19 March 2021

Re: SSD-8996 - Loreto Normanhurst - 91-93 Pennant Hills Road and 6-12 Mount Pleasant Avenue, Normanhurst

I refer to the above amended development proposal and provide the following comments from Council. Please note that these comments are provided by Council officers and are not a resolved position of Hornsby Council.

MARY WARD COURTYARD TREE RETENTION & REMOVAL PLAN

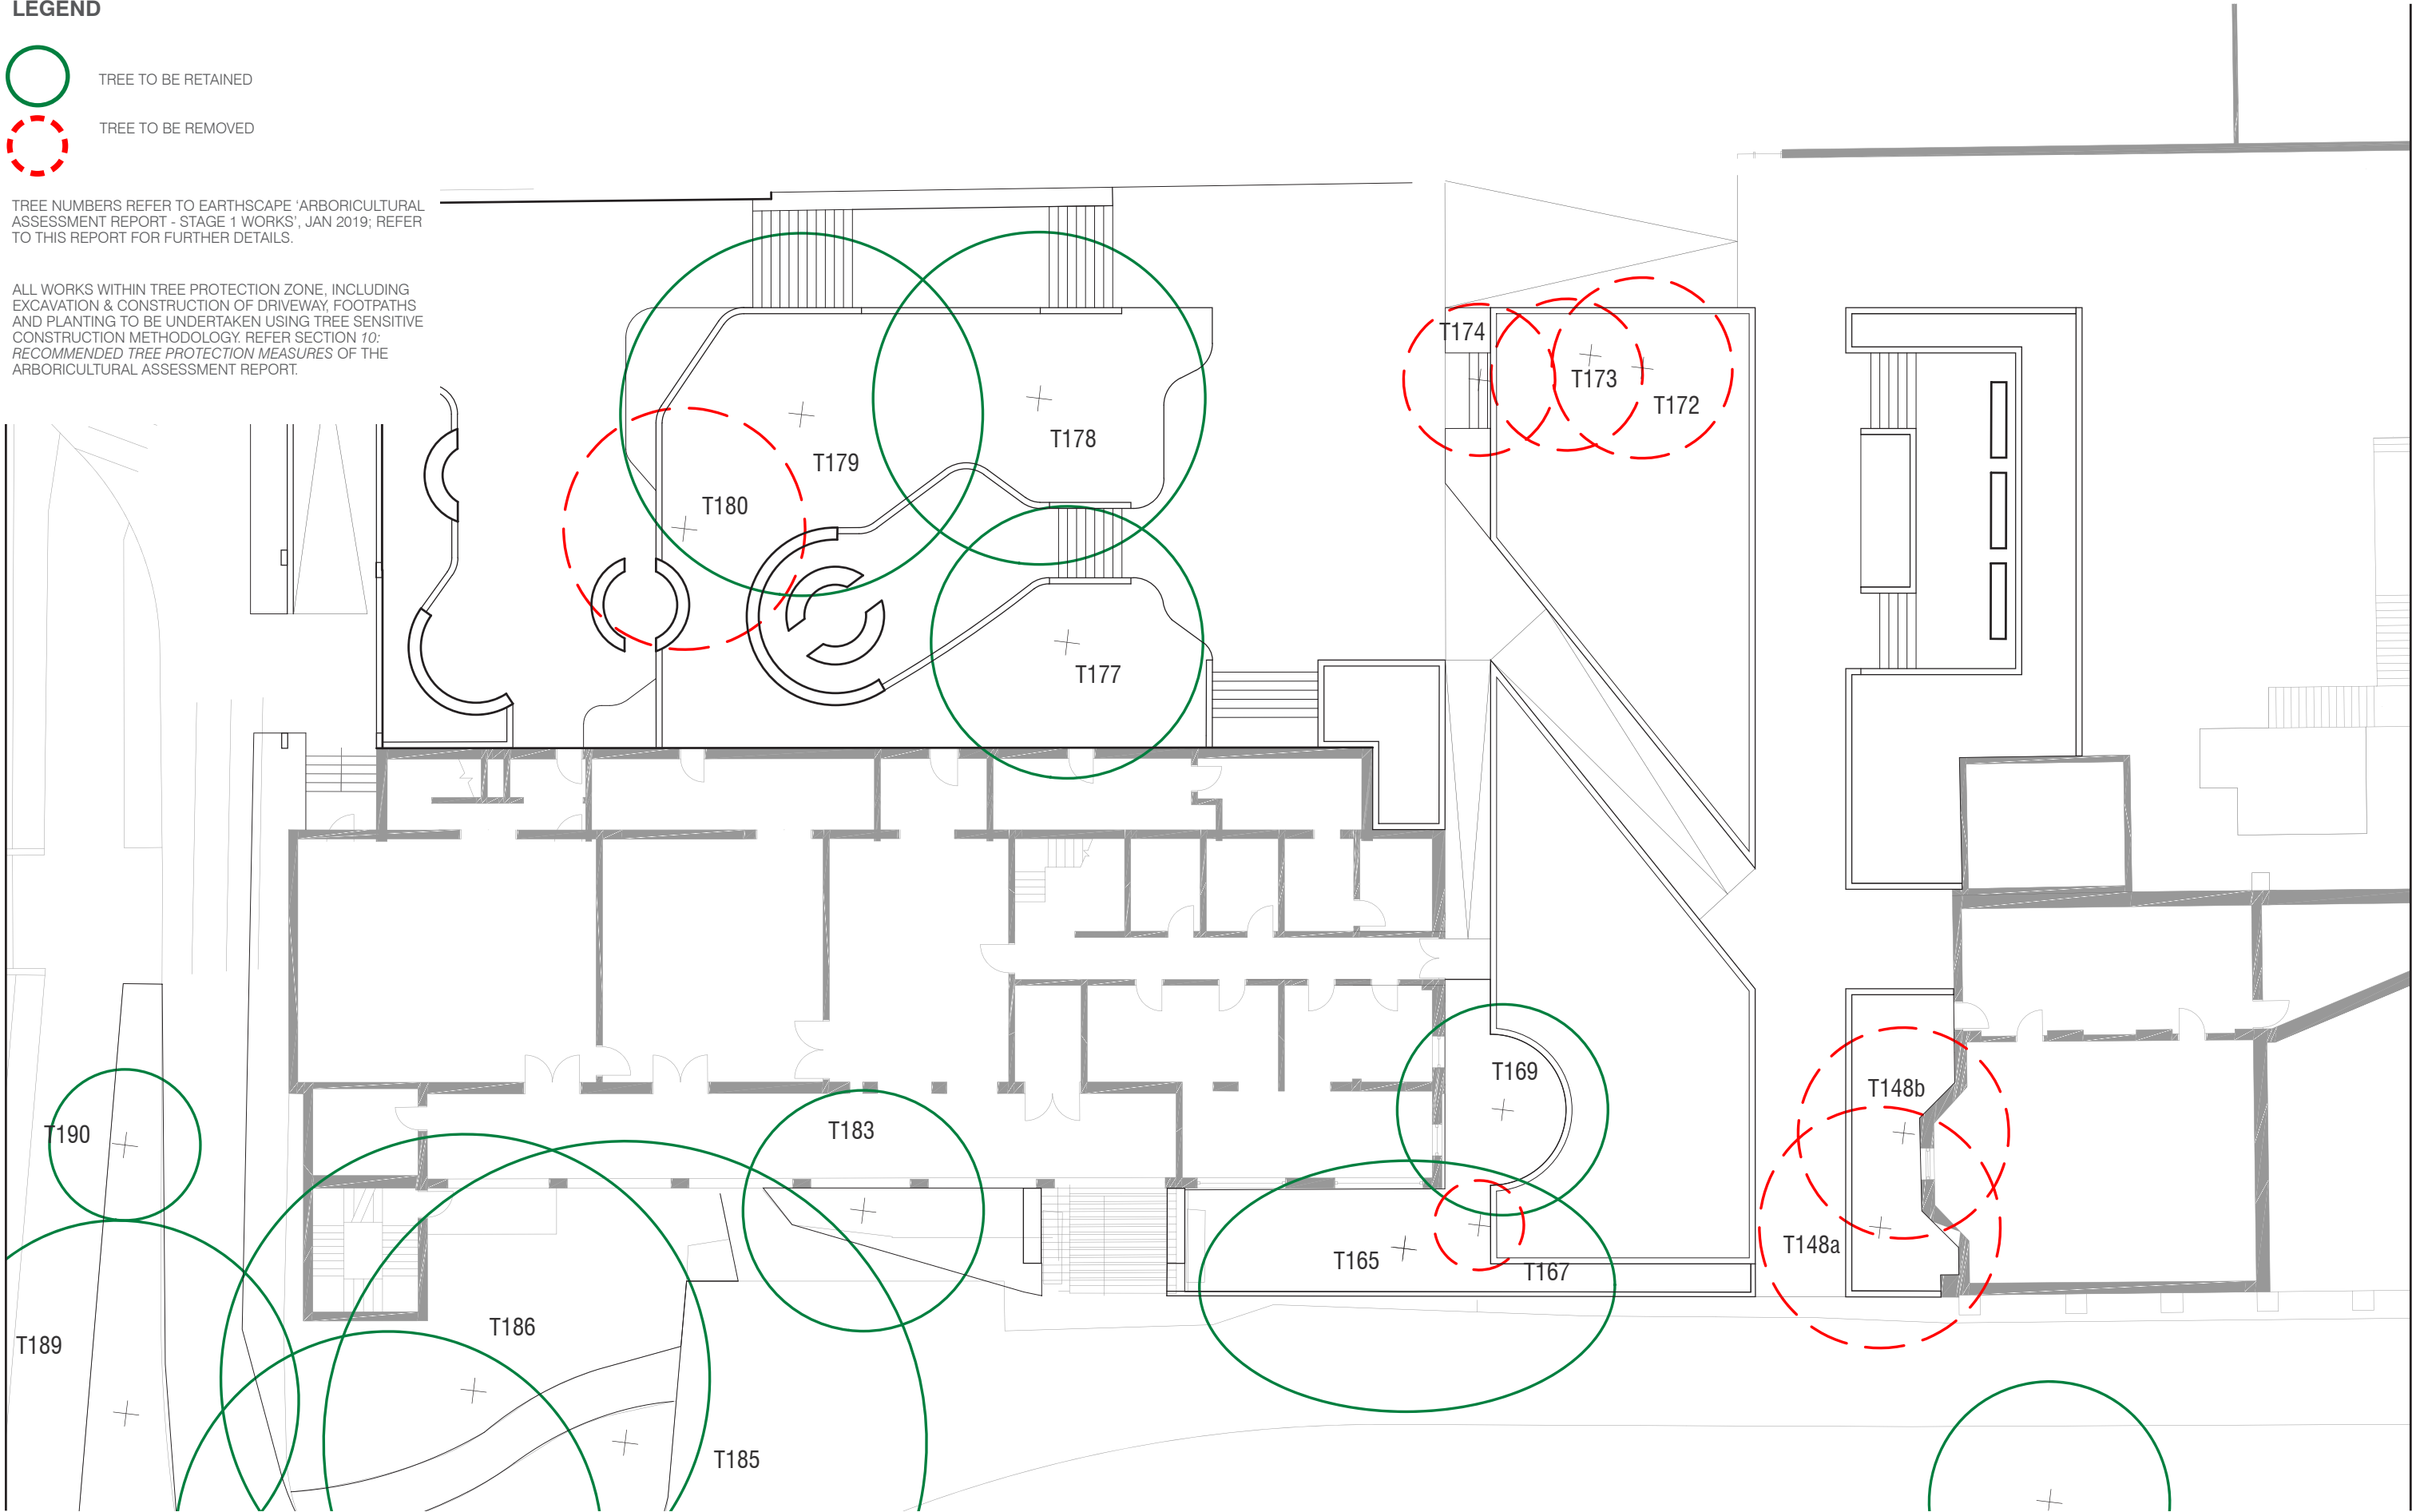
Concerns are raised that 28 trees of medium to high retention value would be removed in the stage 1 development. These trees comprise native species including Spotted Gum, White Mahogany, Narrow-leaved Ironbark Grey Ironbark, Blackbutt, Swamp Mahogany, Sydney Blue Gum, Scribbly Gum, Paperbark and Turpentine.

The trees are of good health and condition and contribute to the amenity of the site and surrounding properties. Should the Department recommend approval of the development, consideration should be given to replacement planting with new trees as part of stage 1 development. Furthermore, a landscape plan should be submitted that clearly indicates the species, location and number of replacement trees to be planted on-site.

CROSS SECTION EE

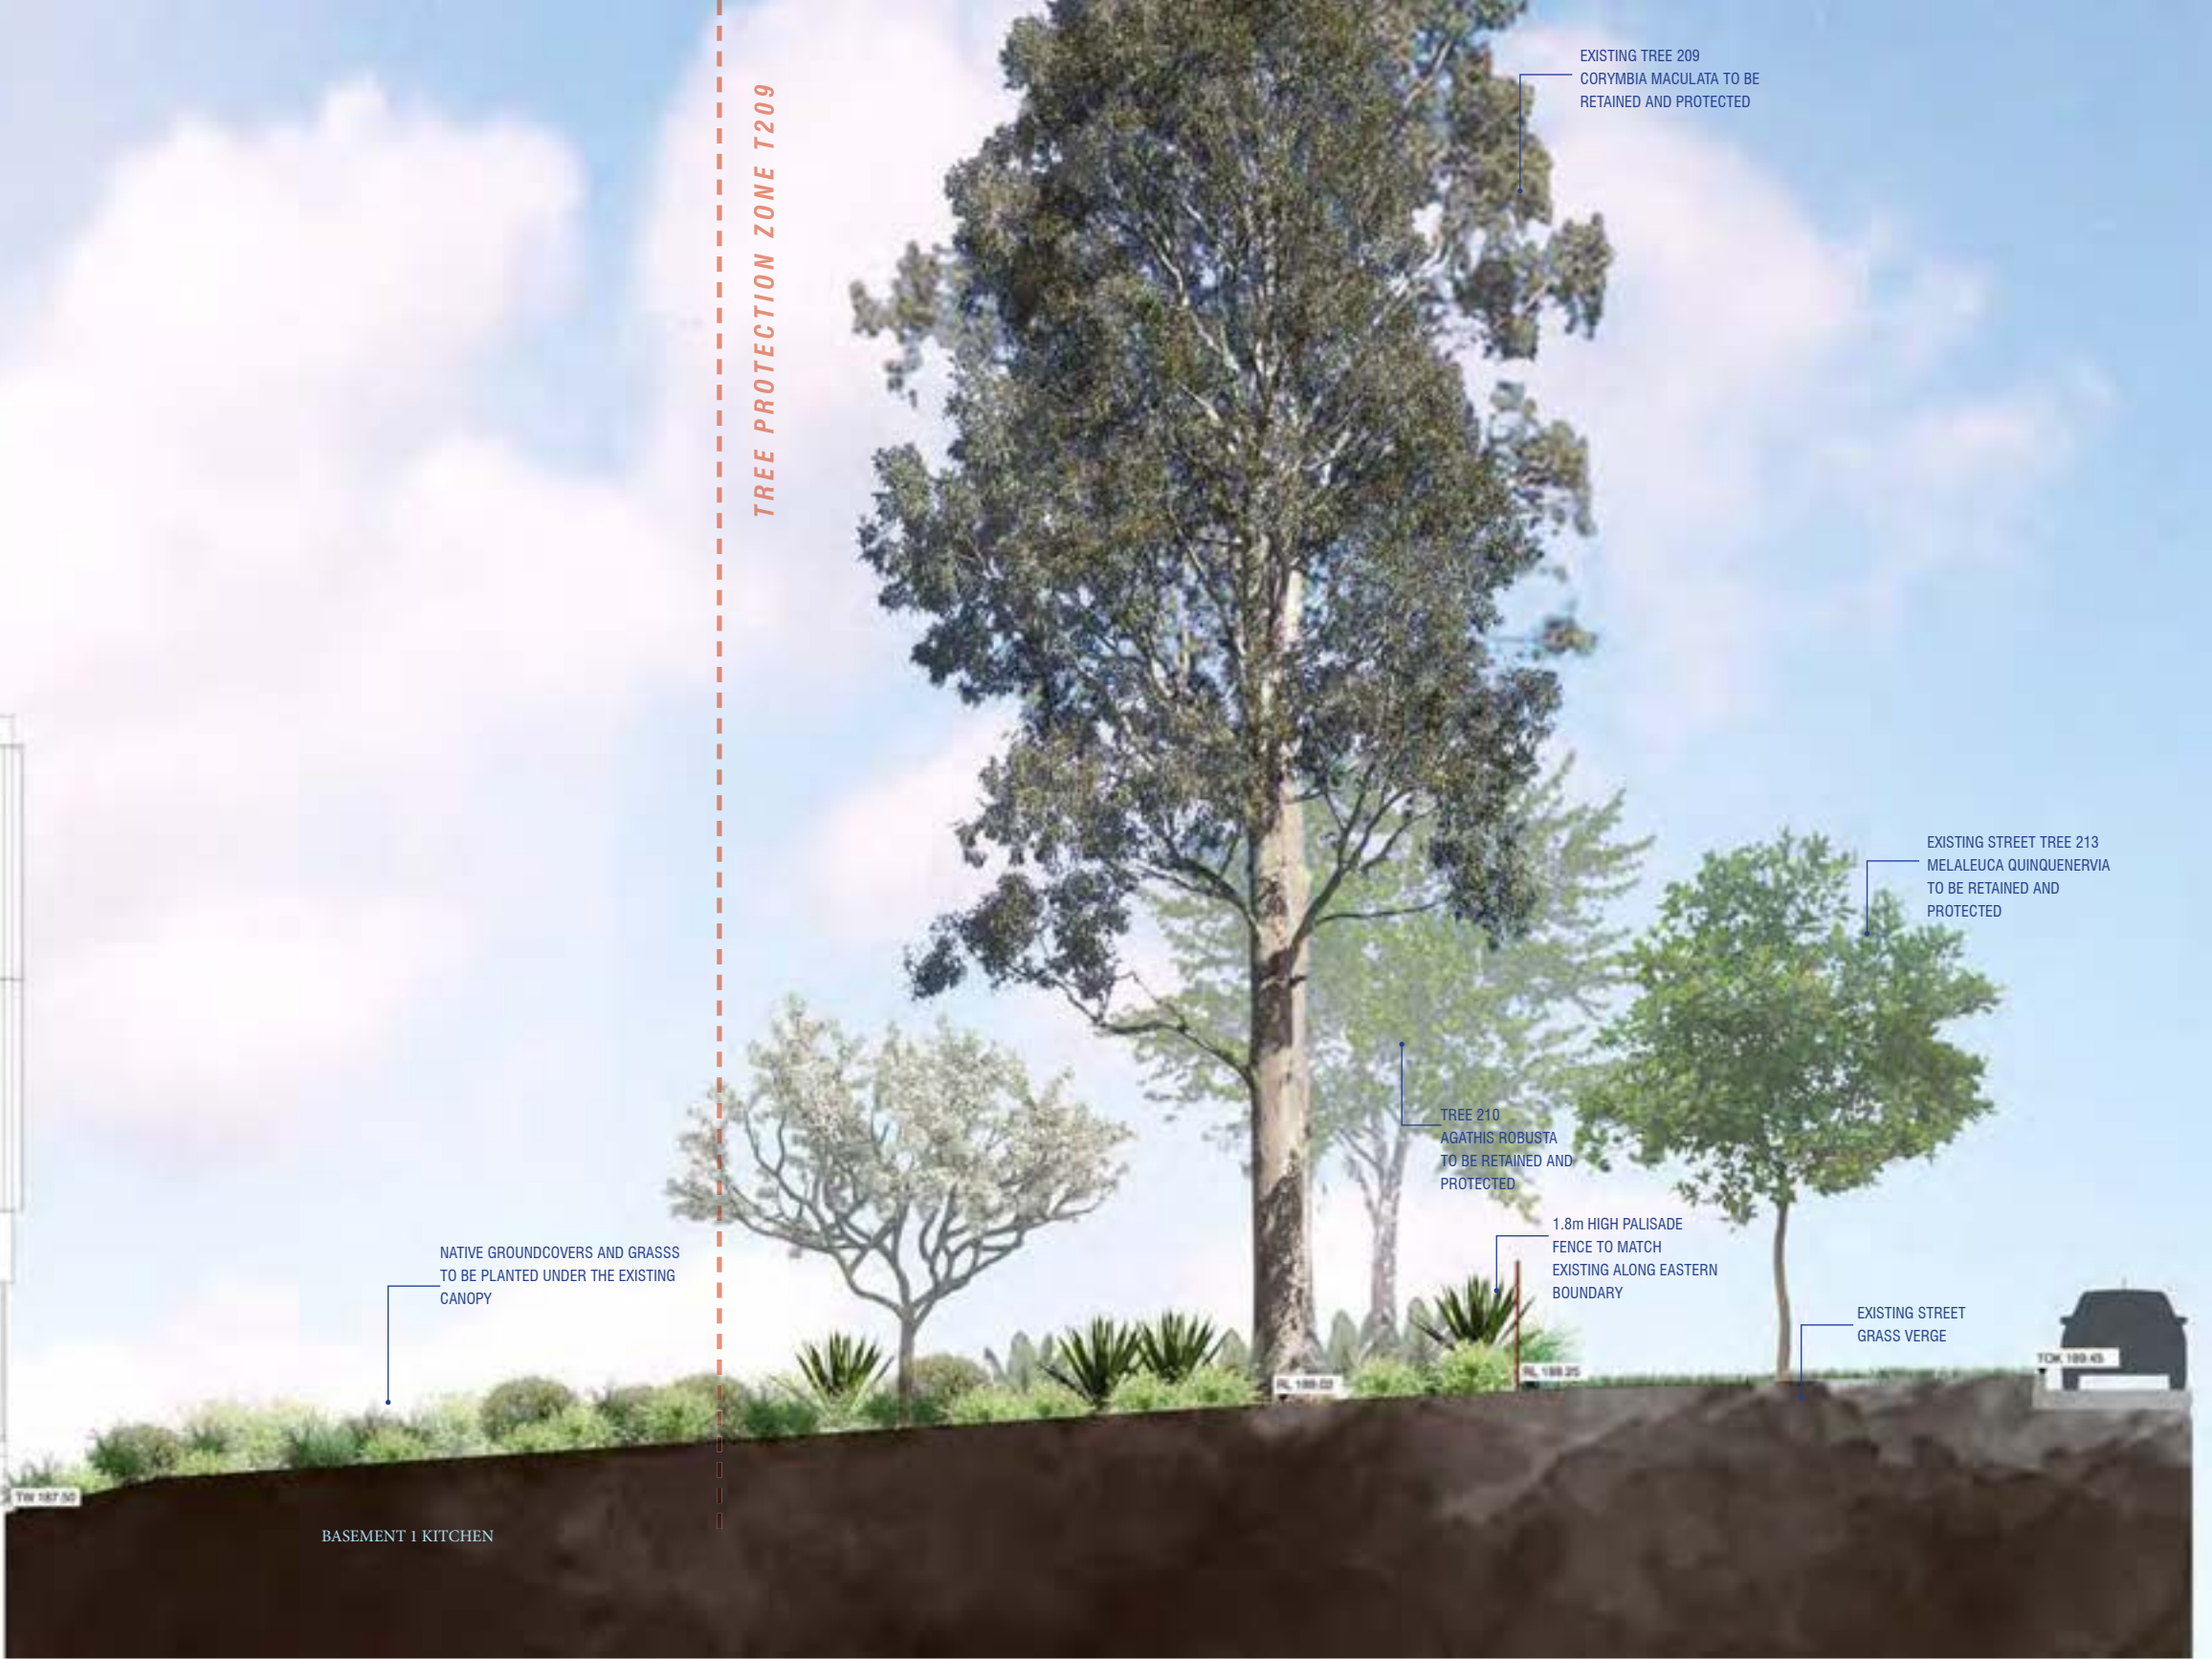
The proposal seeks approval for building envelopes up to a maximum building height of 20.6m and 5 storeys which exceeds the 8.5m height limit for the subject site and surrounding low density area. The proposed boarding school building would front onto low-density residential dwellings and would not provide an appropriate transition in scale of built form as minimal front setbacks are provided to Mount Pleasant Avenue.

The boarding school building would appear as an unbroken building with a building length of approximately 150 metres. This would result in a scale and character that is not typical of a low-density residential zone. Consideration should be given to breaking the building mass and/or setting the building back further into the site to provide greater opportunity for deep soil planting along the street frontage. It should be noted that where residential buildings of 5 storey are permitted in Hornsby Shire, they are restricted to a maximum building length of 35m with indentations to provide variation to the building facades. The proposal does not satisfy Council's controls for landscaping, setbacks or built form and articulation.
